Permit Number: 071288

has permission to Change of use w/ tenant fit-out from Multi-Family to 2 Family

AT 11 DEERING ST PORTLAND, OR 97201 046 B022001

Dept: Building **Status:** Approved with Conditions **Reviewer:** Chris Hanson **Approval Date:** 12/10/2007

Third Floor Section B - B
 1/4" = 1' - 0"

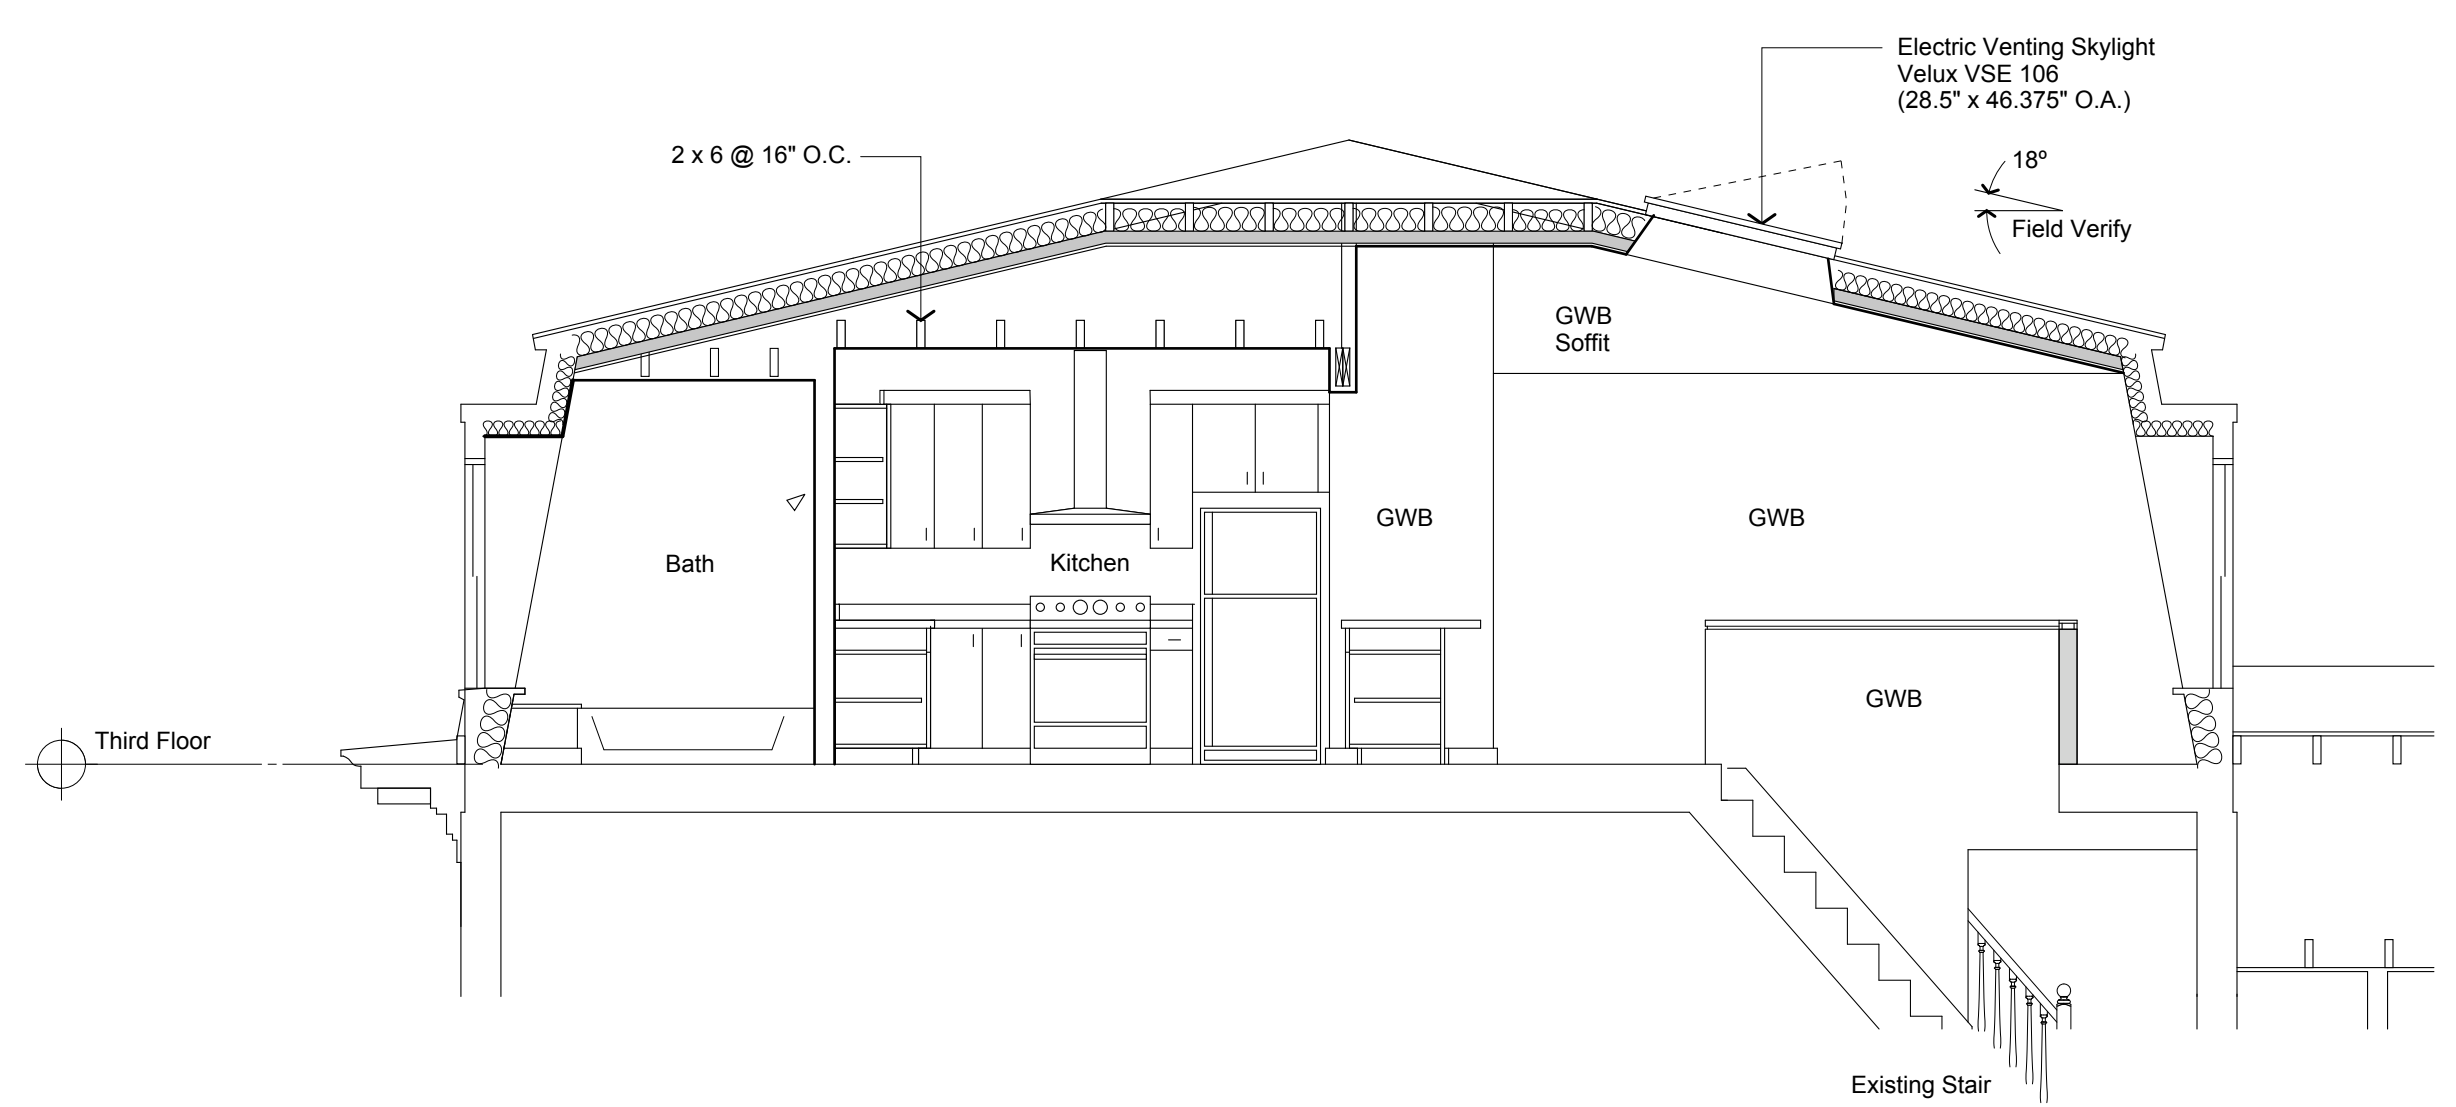
- 1) This permit is being approved on the conition that the seperation of 11 and 13 will be an approved UL listed assembly as req. For a 2 hour seperation.

- 2) All bedrooms shall have at least one code compliant egress window
- 3) prior to close -in a U.L. Listed 2 hour demising wall must be approved by this office Chris Hanson

- 10 All penetrations between dwelling units and dwelling units and common areas shall be protected with approved firestop materials, and recessed lighting/vent fixtures shall not reduce the (1 hour) required rating.
